From: Michael Eastham
Sent: 31 January 2019 16:07
To: Planning.Responses
Subject: FW: Walberton - Today's Development Team Meeting

Please upload the email from ADC Drainage and the attachments onto Ocella for WA/95/18/RES – Land East of Tye Lane, Walberton.

From: Laura Gibbons
Sent: 31 January 2019 12:02
To: 'Laura Humphries'
Cc: Michael Eastham
Subject: RE: Walberton - Today's Development Team Meeting

PRIVATE MANHOLE TYPE A
(DEPTH FROM COVER LEVEL TO SOFFIT OF PIPE 3.0-6.0m)

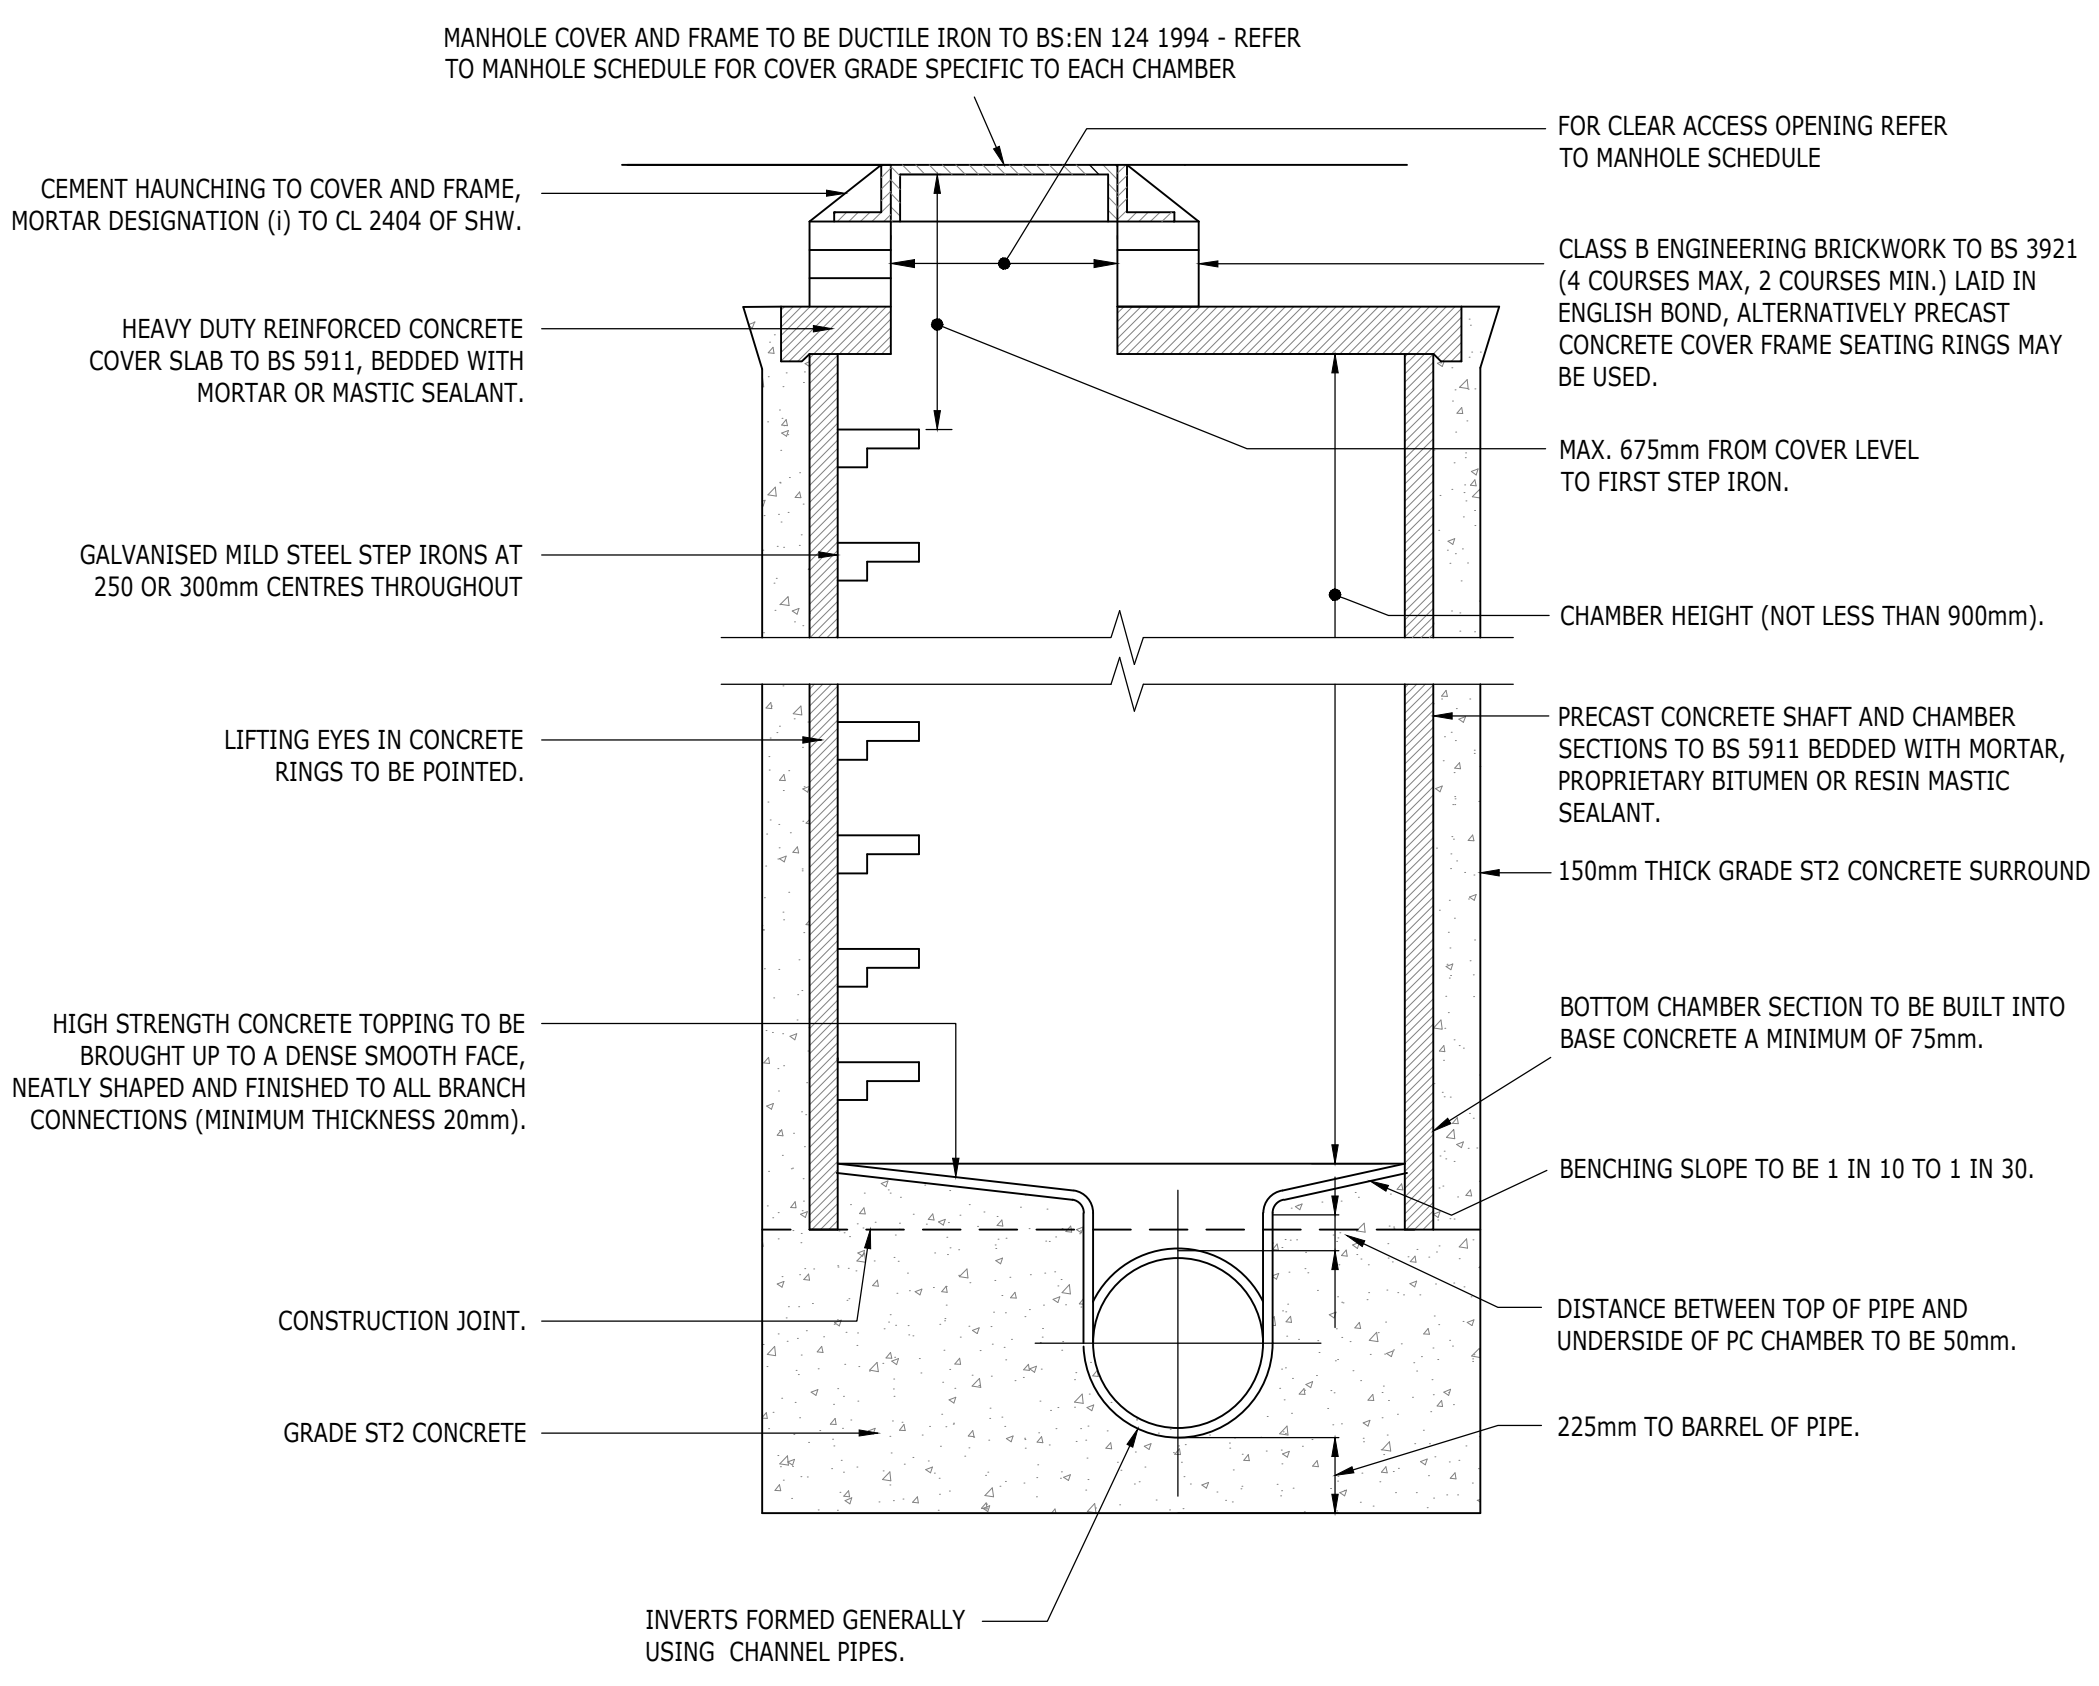
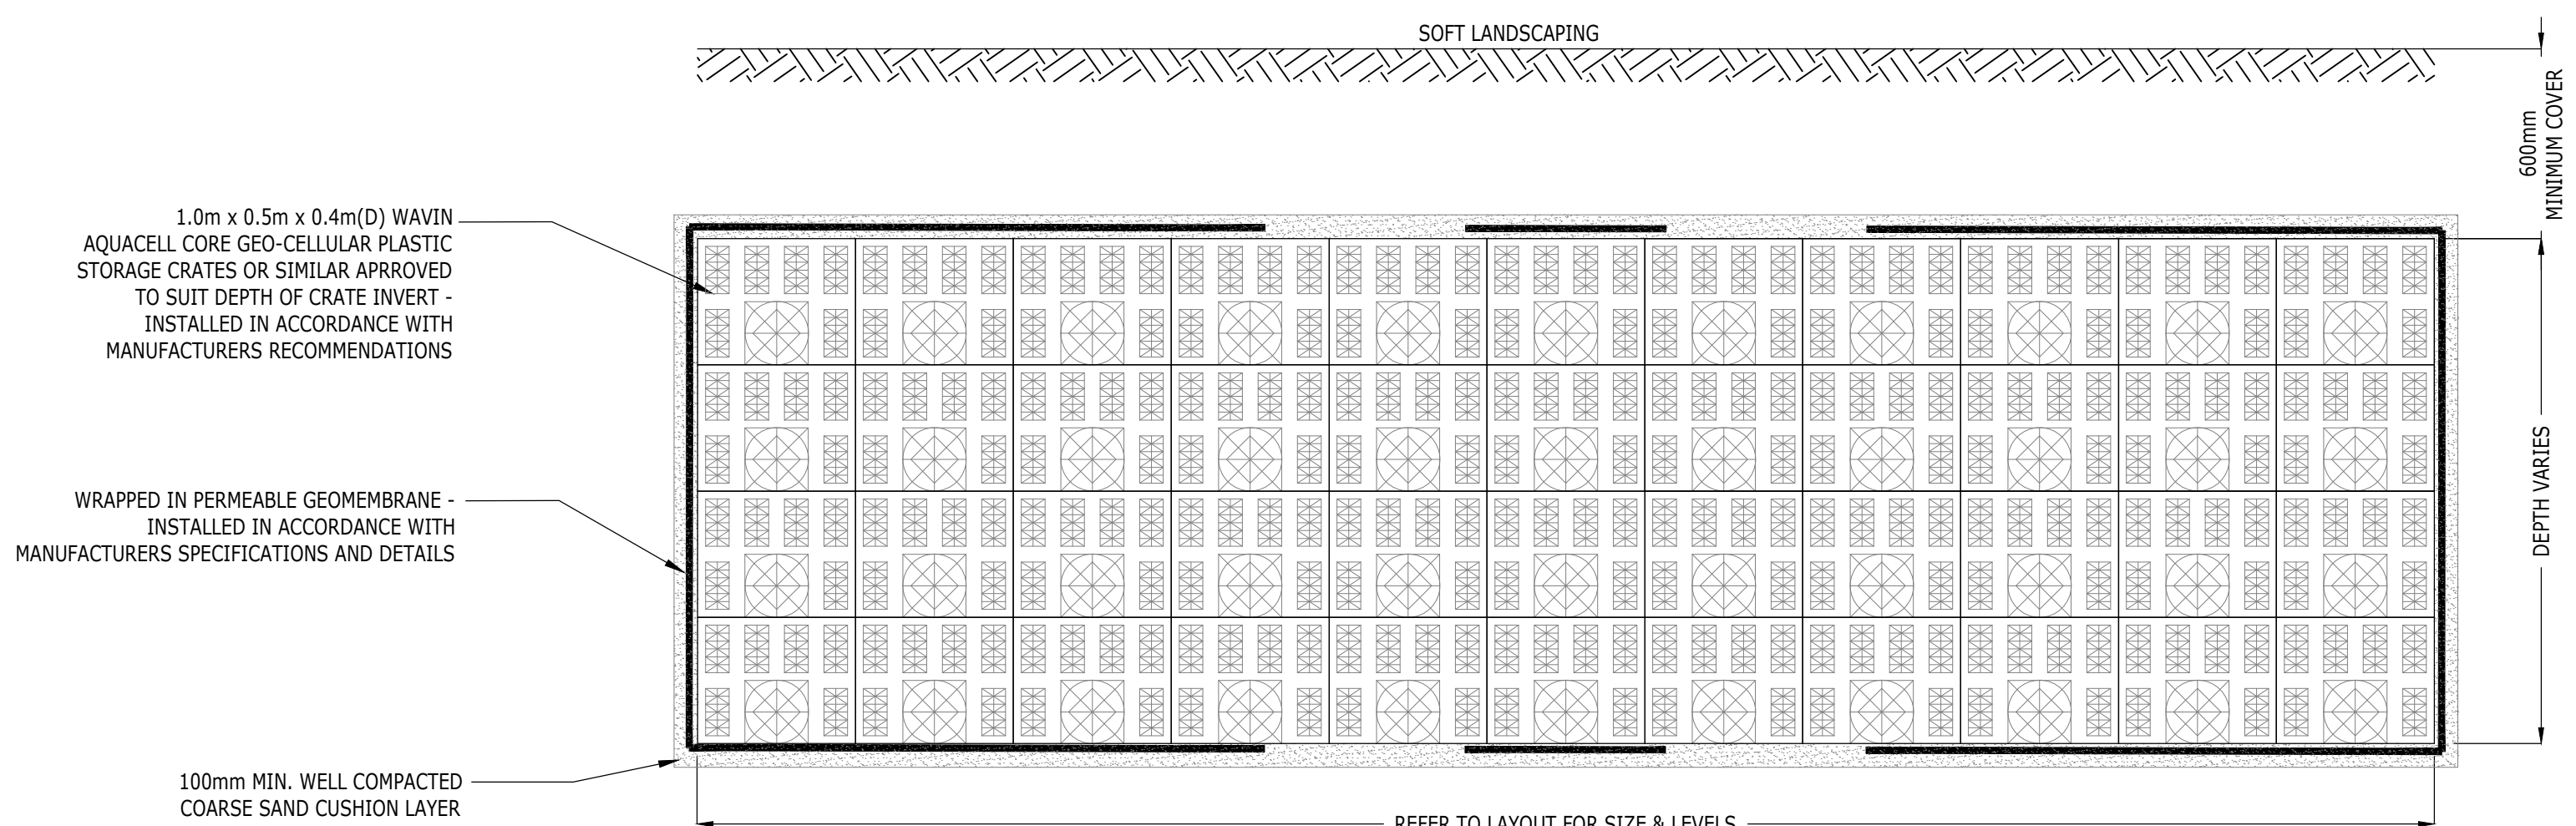
14. Permeable paving construction details need to show permeable geomembrane fully wrapping around the subbase.
15. All other construction details must be provided with the DOC application, not just reference to Sewers For Adoption.
